Application for Removal or Variation of a Condition following Grant of Planning Permission or Listed Building Consent

Installation of a new shop front, provision of balcony with 1.1m high privacy screen to rear 2nd floor, installation of roof lantern to rear and use as altered as retail and office space at ground floor and 2 serviced holiday flats to 1st and 2nd floors

23/0411

Condition 2: Change approved drawings: A023/061/BR/02 Revision A to A023/061/BR/02 Rev B and A023/061/BR/01 Revision D to A023/061/BR/01 Revision E

DRAWING No. AO23/06/1/BR/O1 Revision E

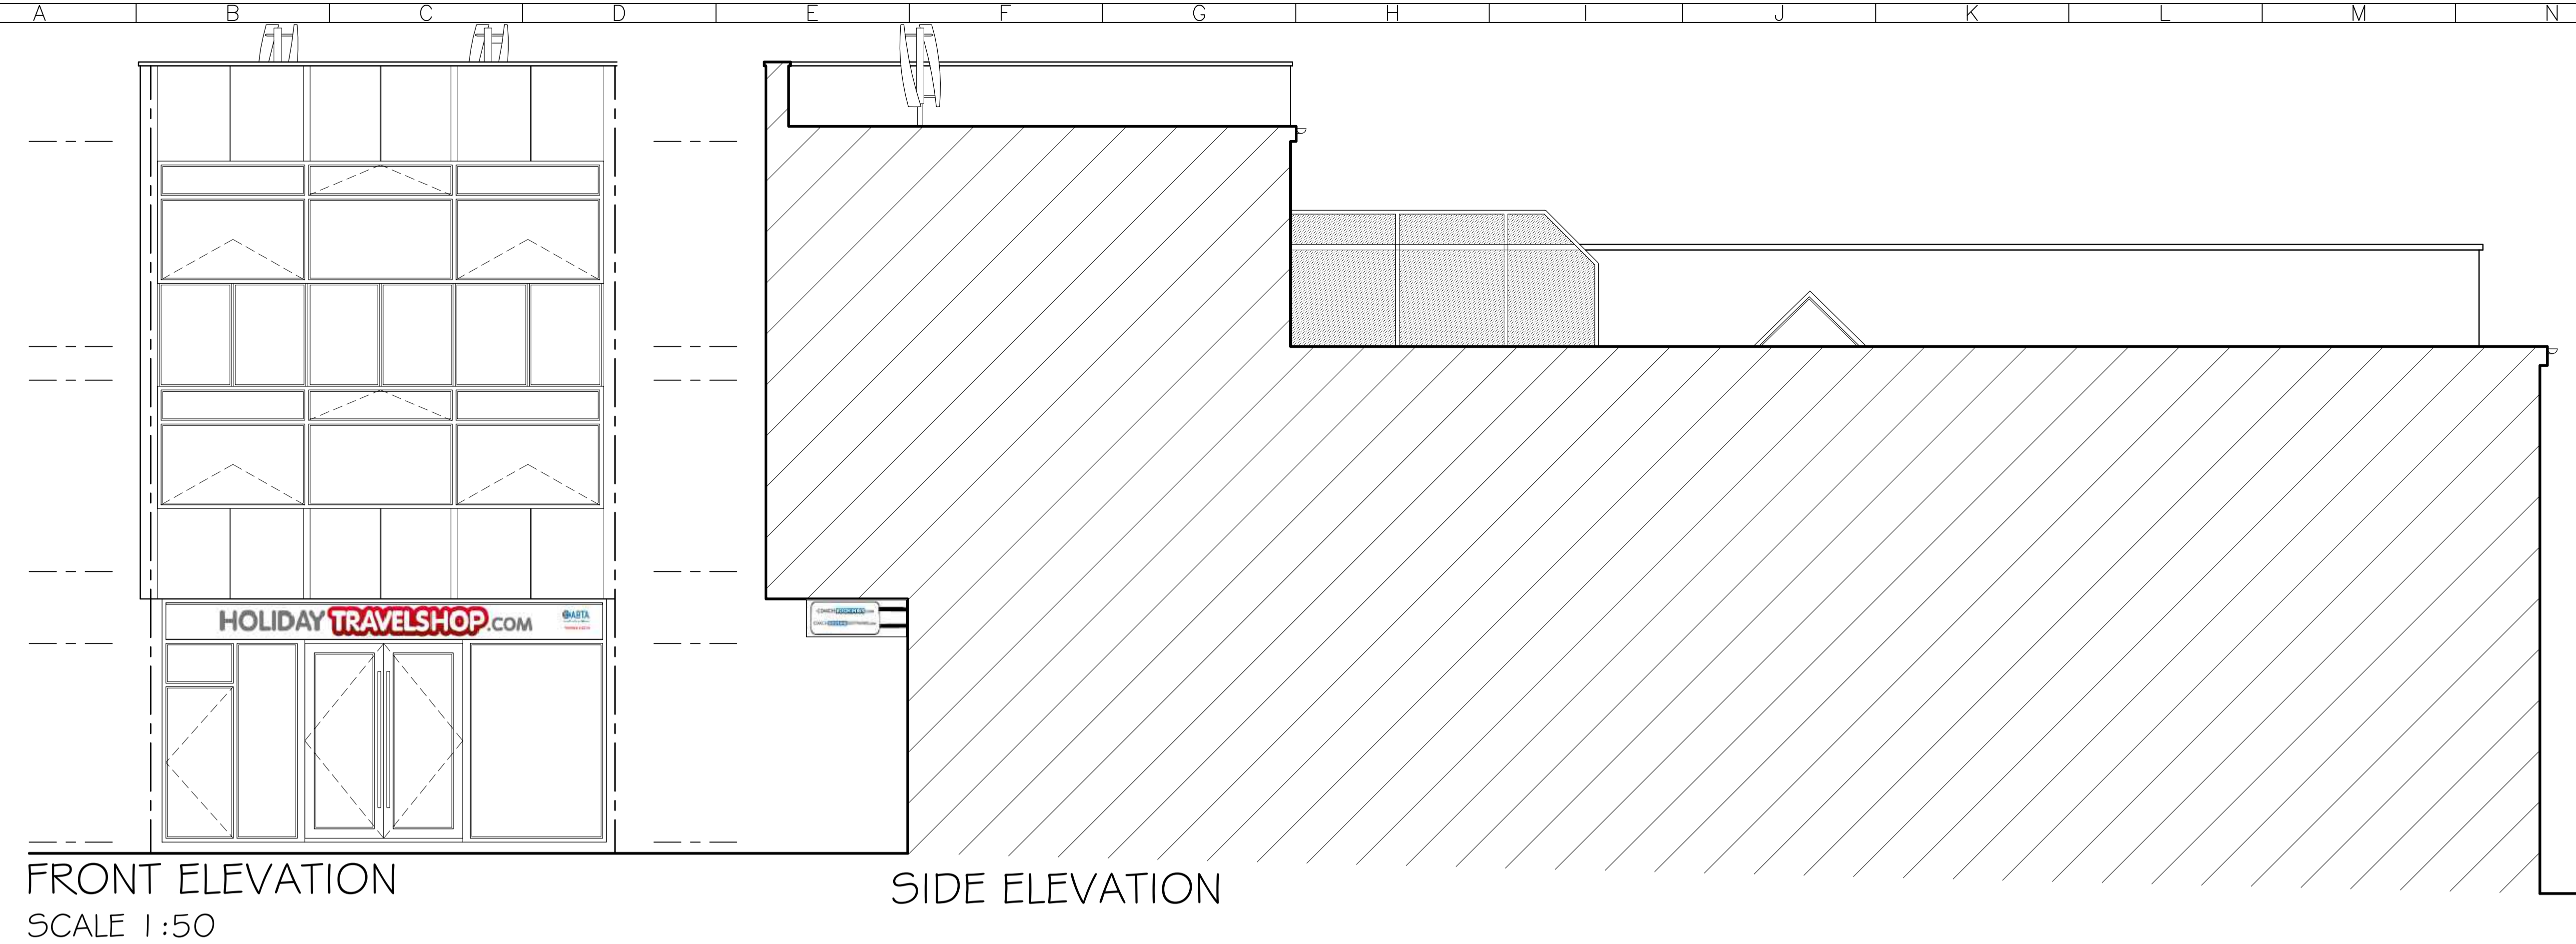
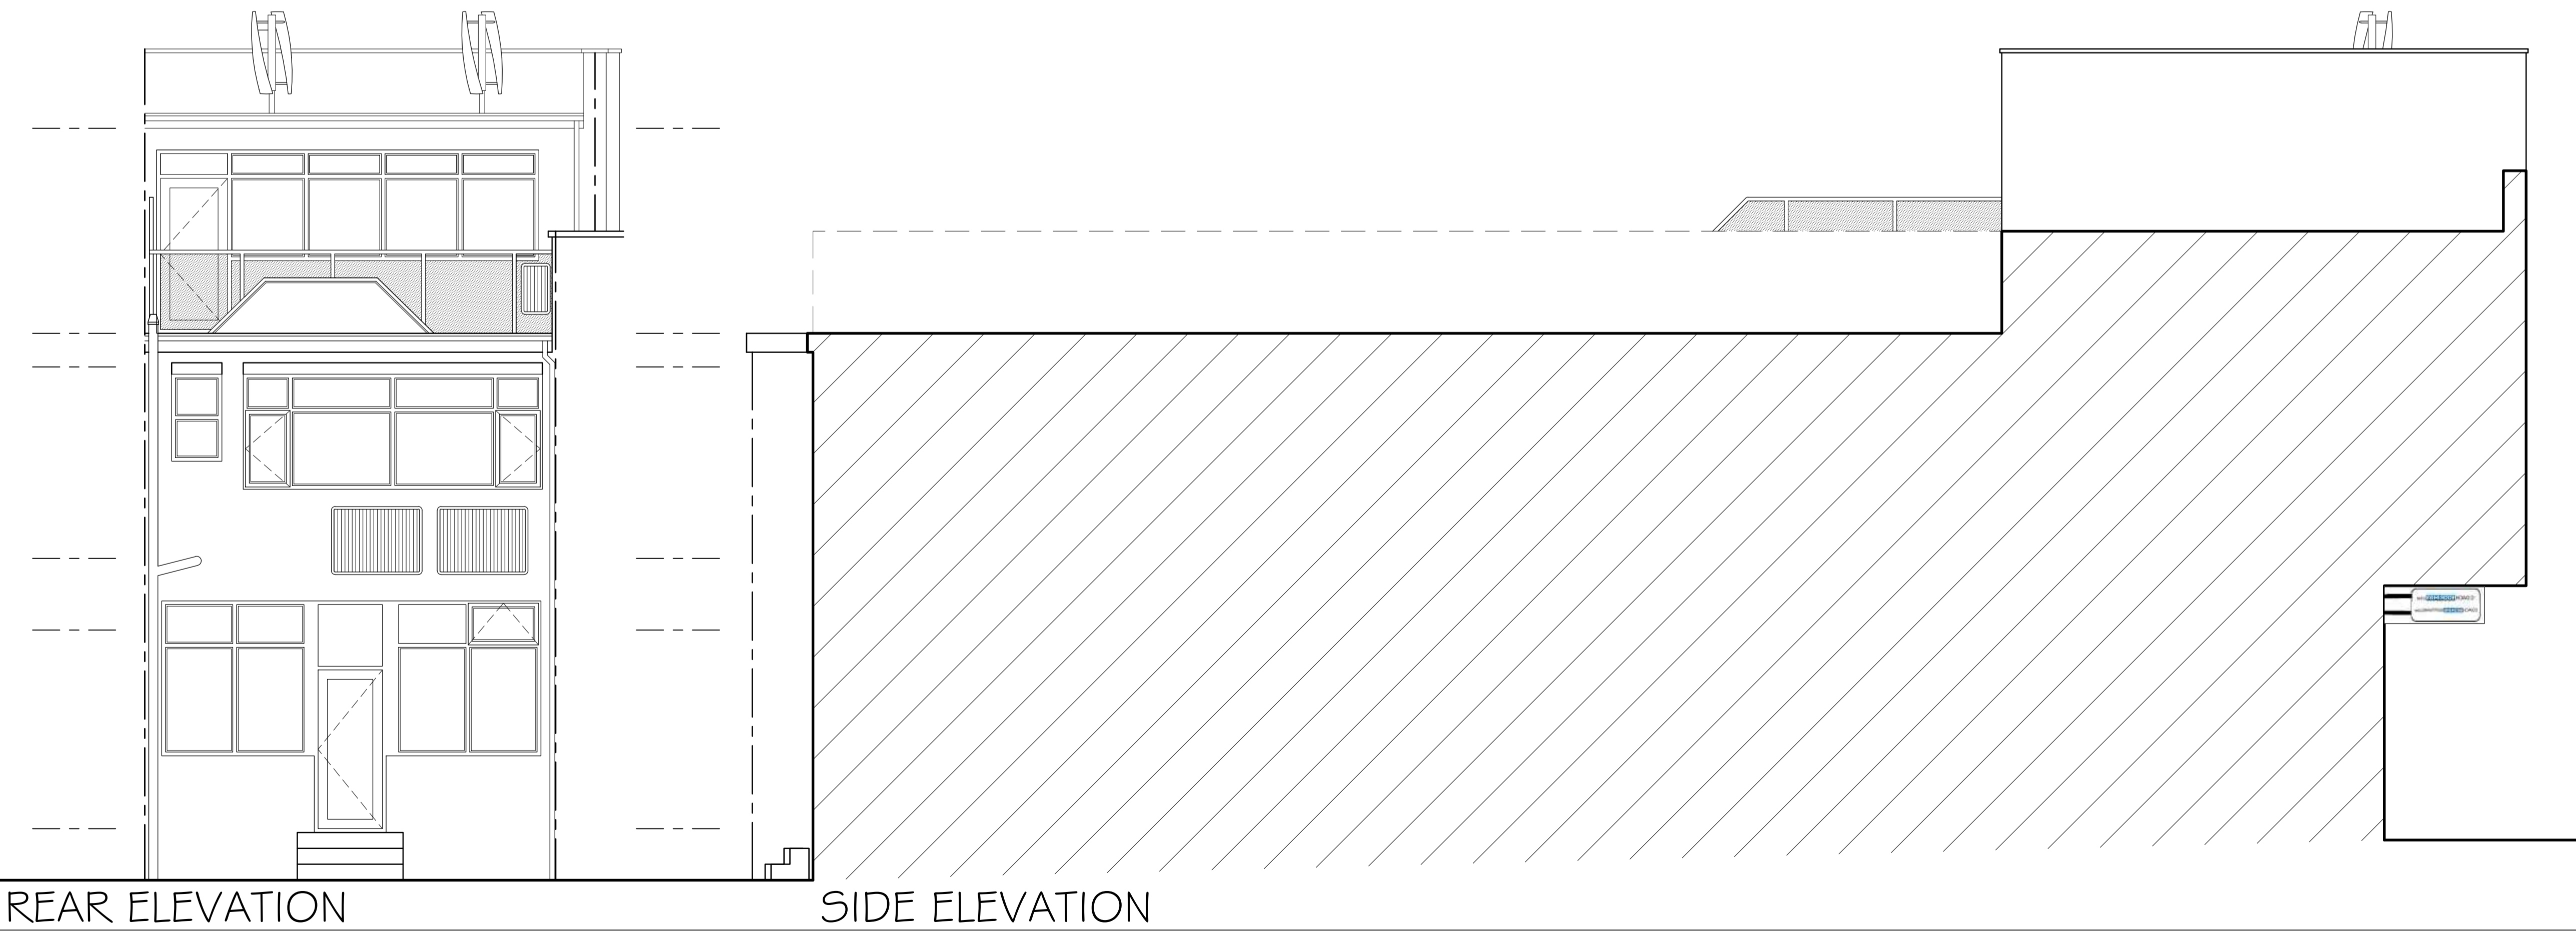
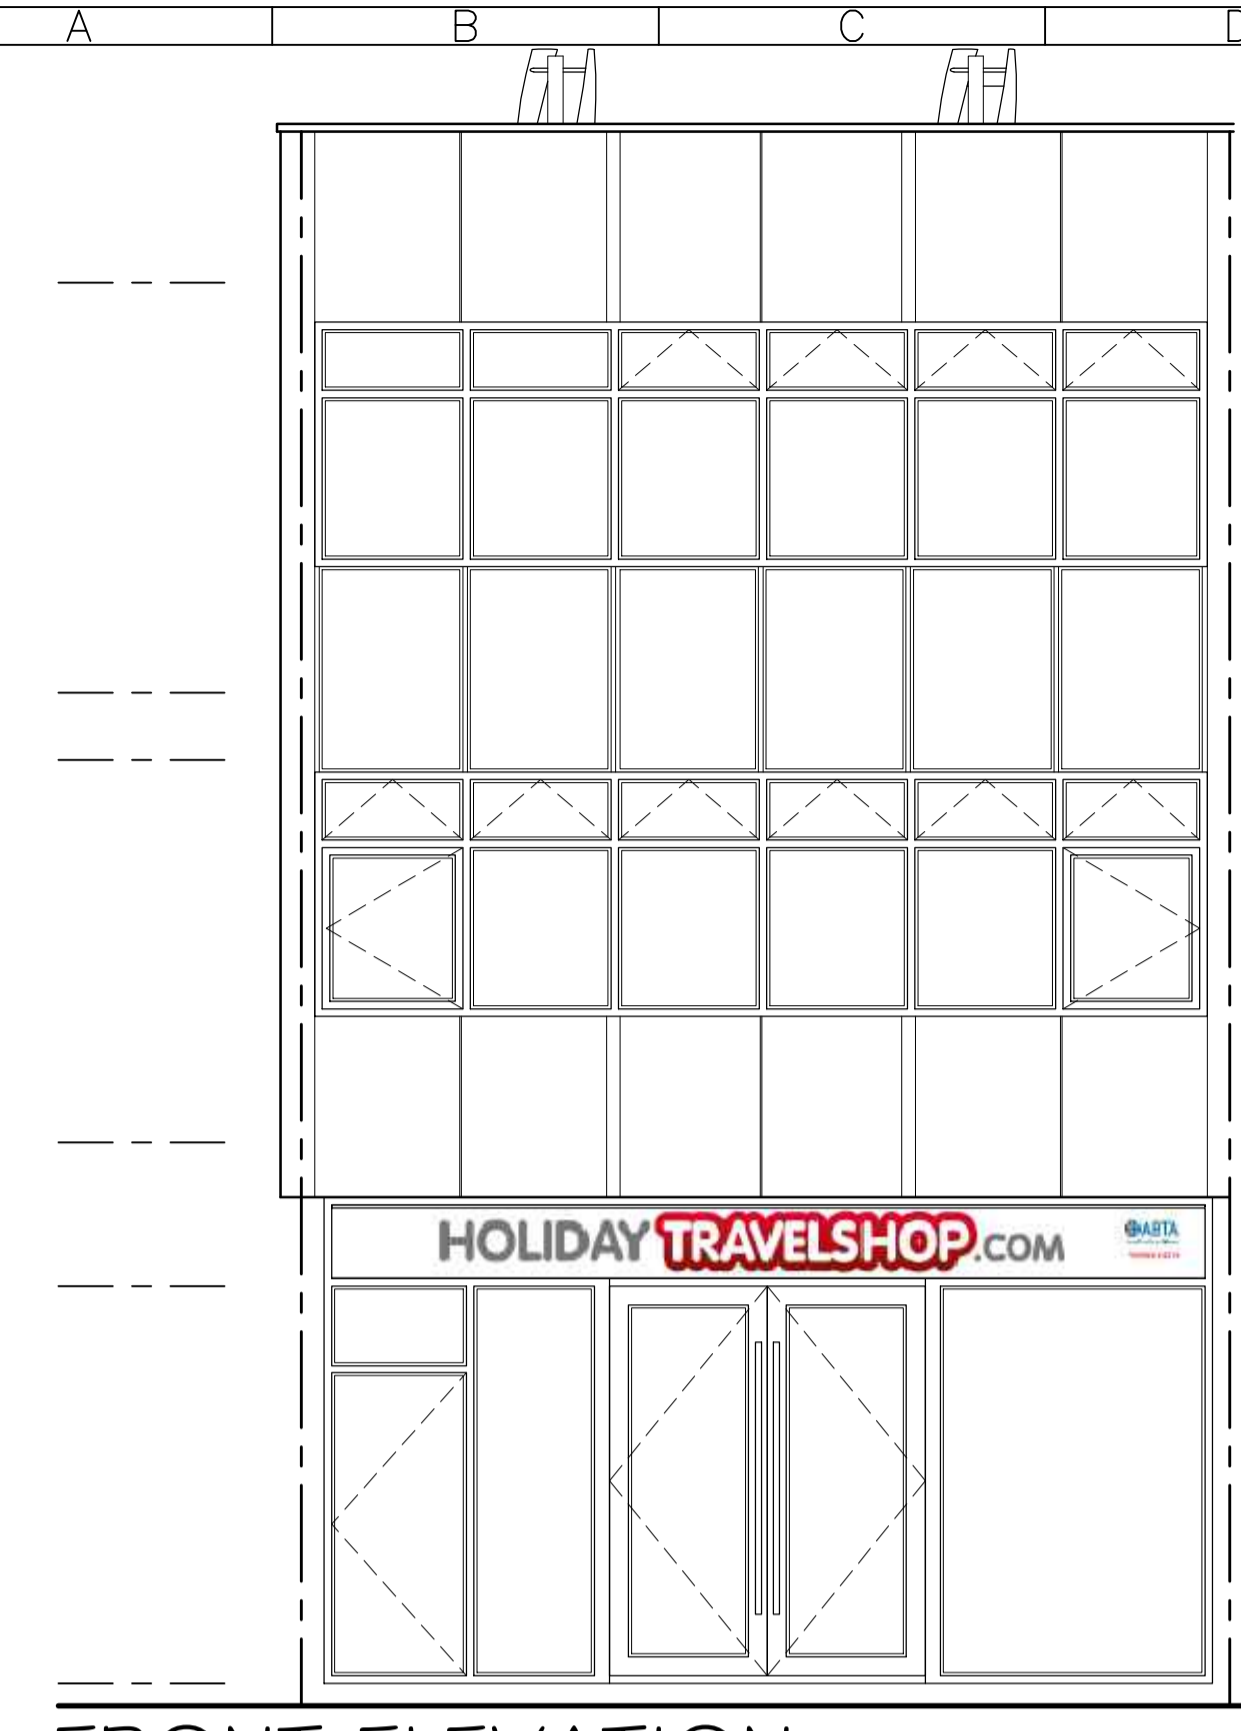
Sub divide the windows to make more user friendly and increase security to the ground floor
